Re: Traffic Noise Cover Letter Rideau & Chapel, Ottawa GWE File No.: 19-010 – Cover Letter

This letter describes how we have addressed comments prepared by the City of Ottawa in their memo dated June 4, 2019, pertaining to the traffic noise assessment performed for the proposed mixed-use development located at 151-153 Chapel Street in Ottawa, Ontario. Below is a summary of how each of the comments relating to the noise study have been addressed. The number sequence below is in reference to each of the numbered comments continued in the memo.

2ND FLOOR

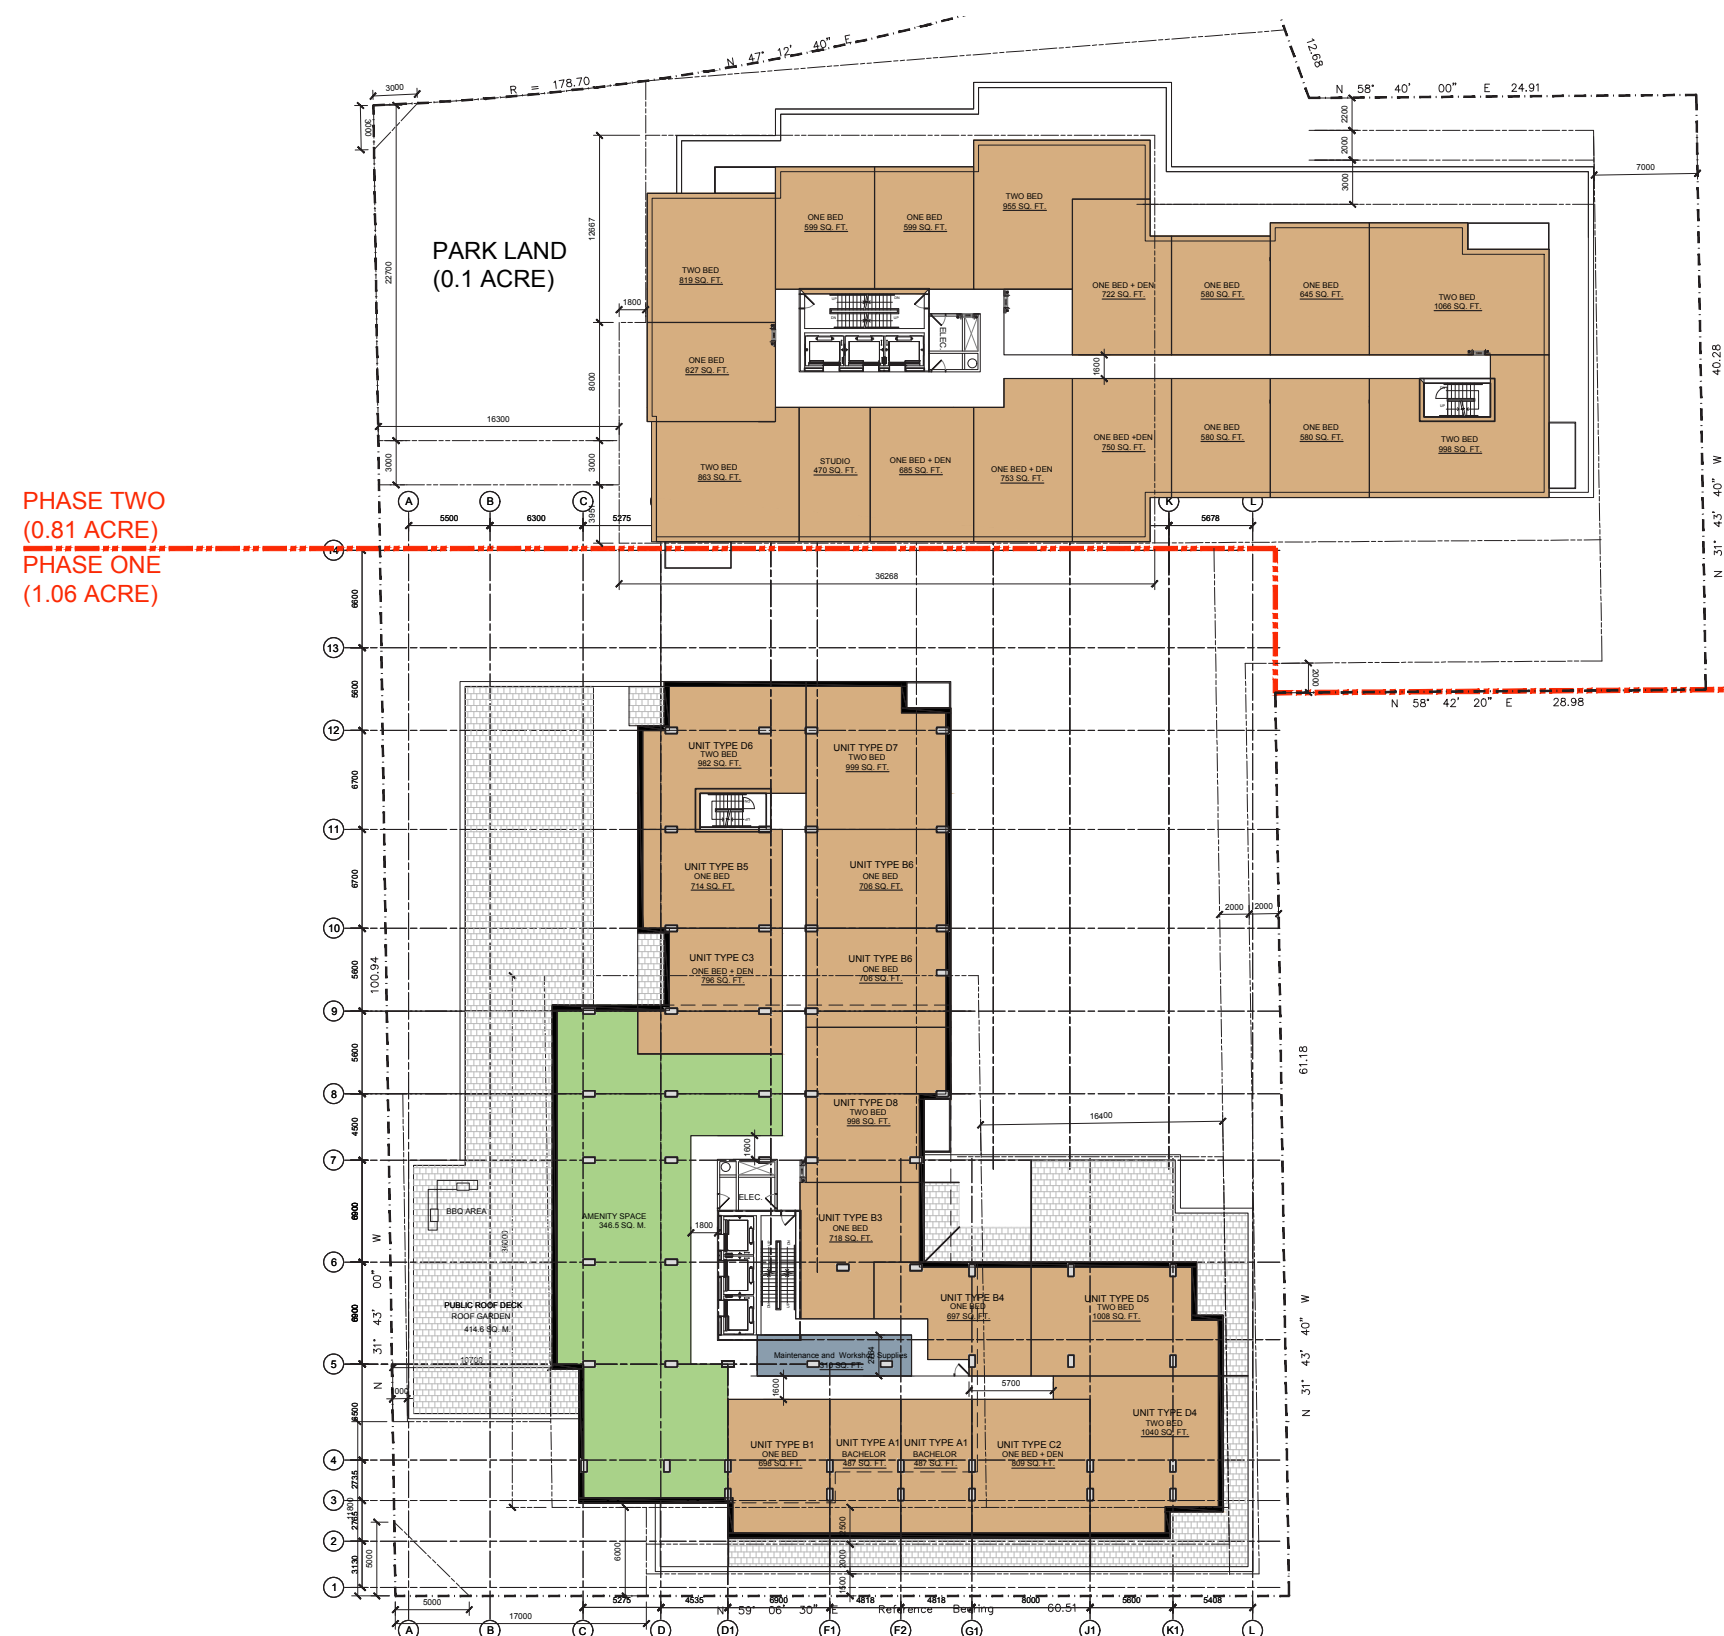
67. OLA at 2nd Storey requires mitigation. Please provide shop drawings and material specifications prior to SPC approval or a condition will be applied to the SPC Agreement for this item.

GWE Response: Executive Summary indicates that this information is to be provided once available.

10TH FLOOR

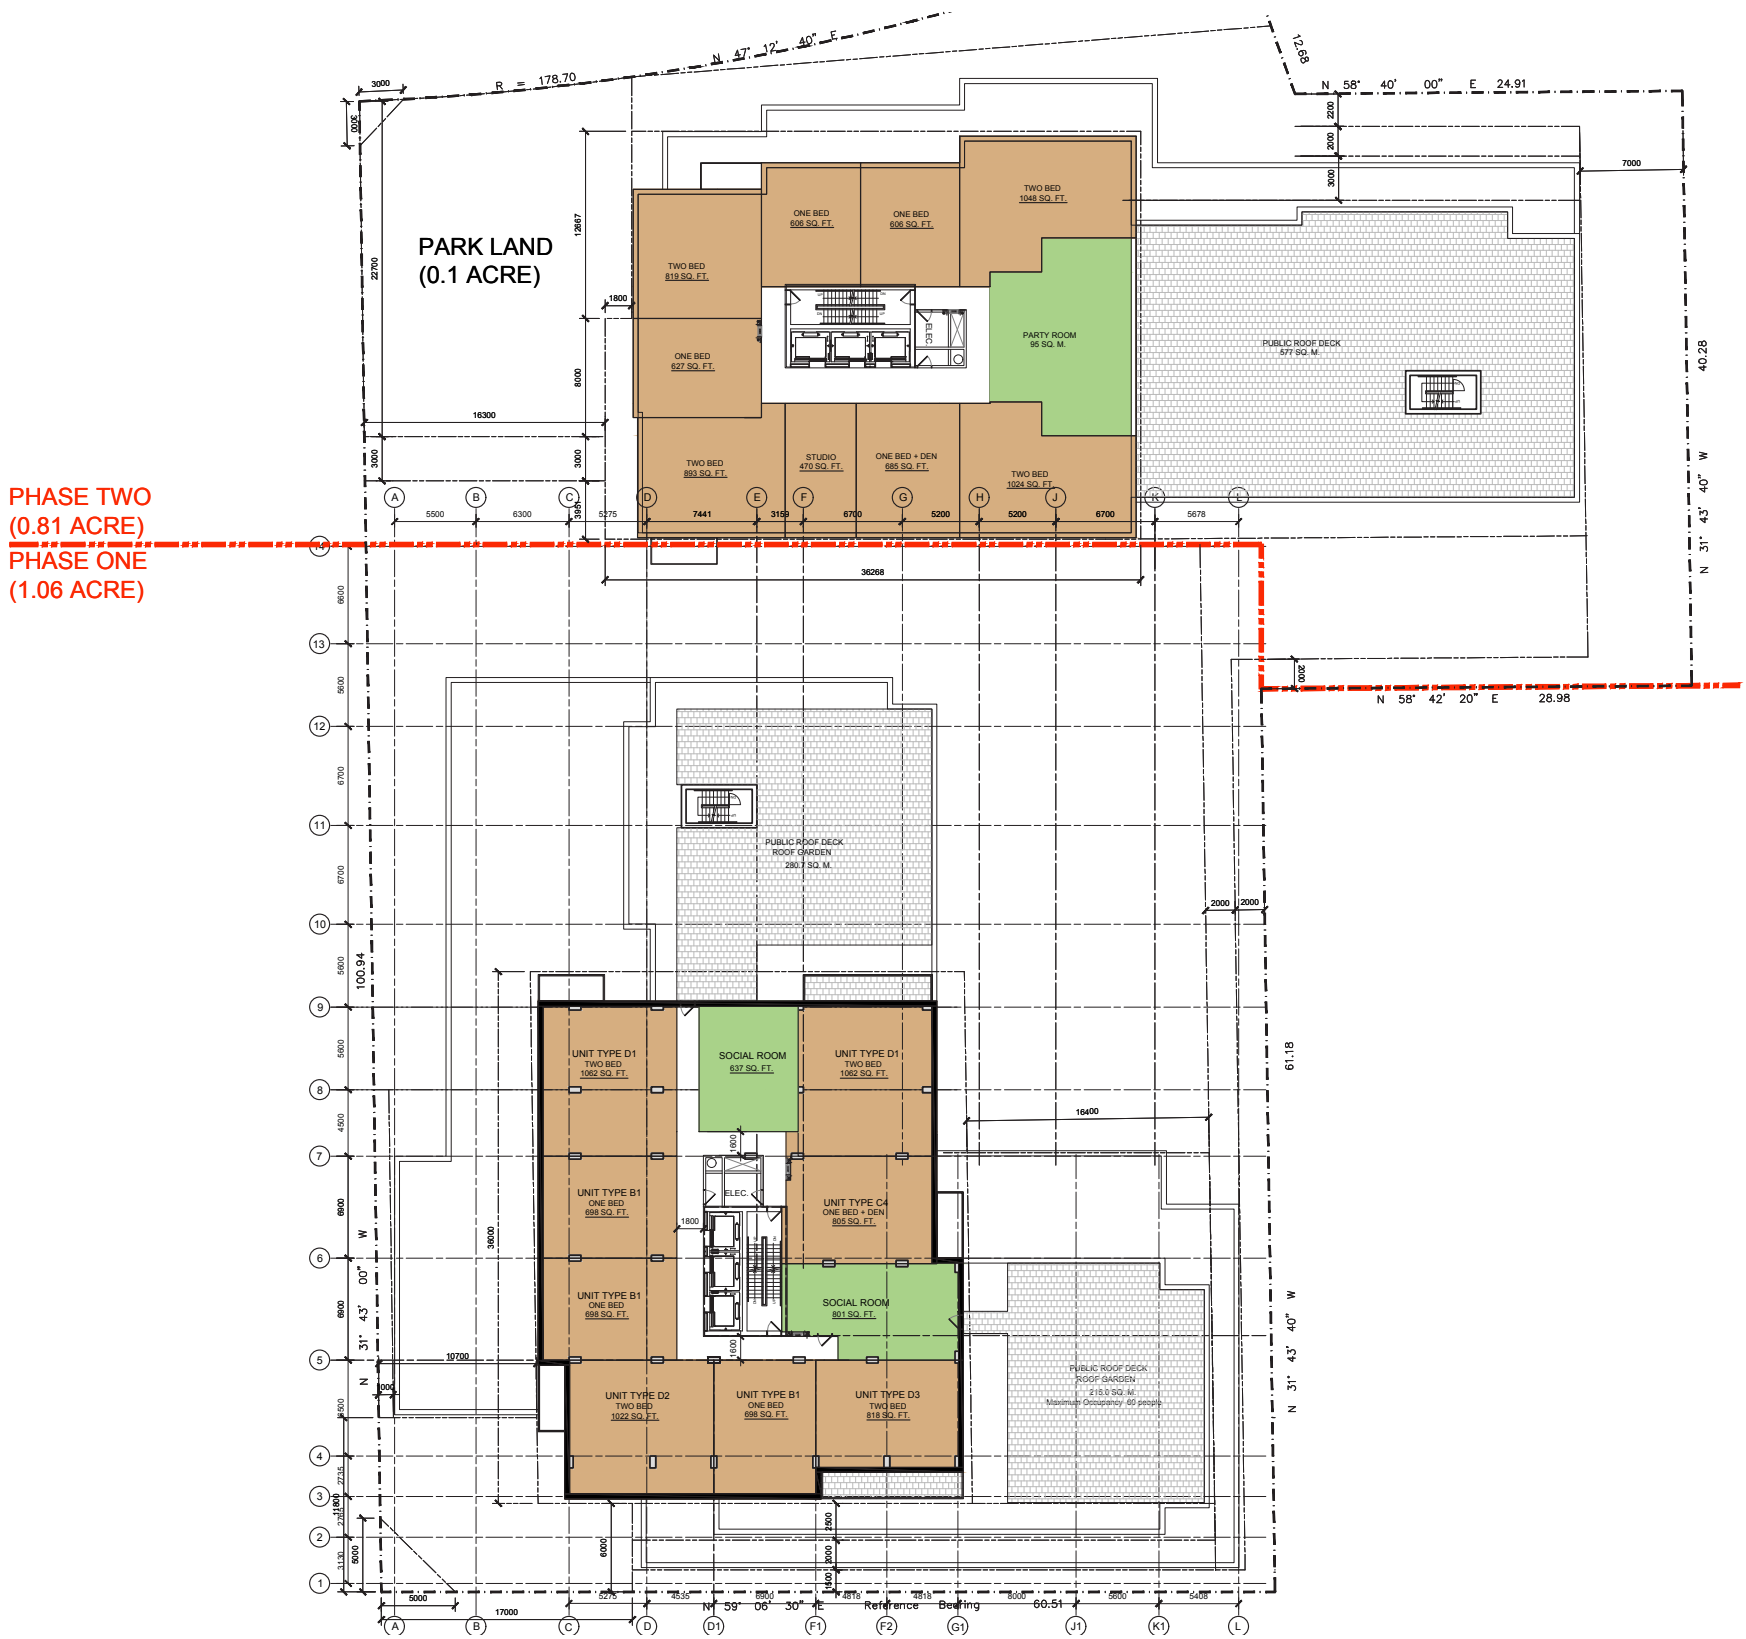
66. Please speak to the OLA on the 10th Storey and to whether mitigation is required or not. If applicable, please provide boundaries etc.

GWE Response: Noise levels at the 10th Floor Terrace (R16 – Table 3) are below 55 dBA during the daytime period, therefore mitigation is not required. Other areas of 10th Floor terrace have additional blockage from building massing; therefore, noise levels will be lower.
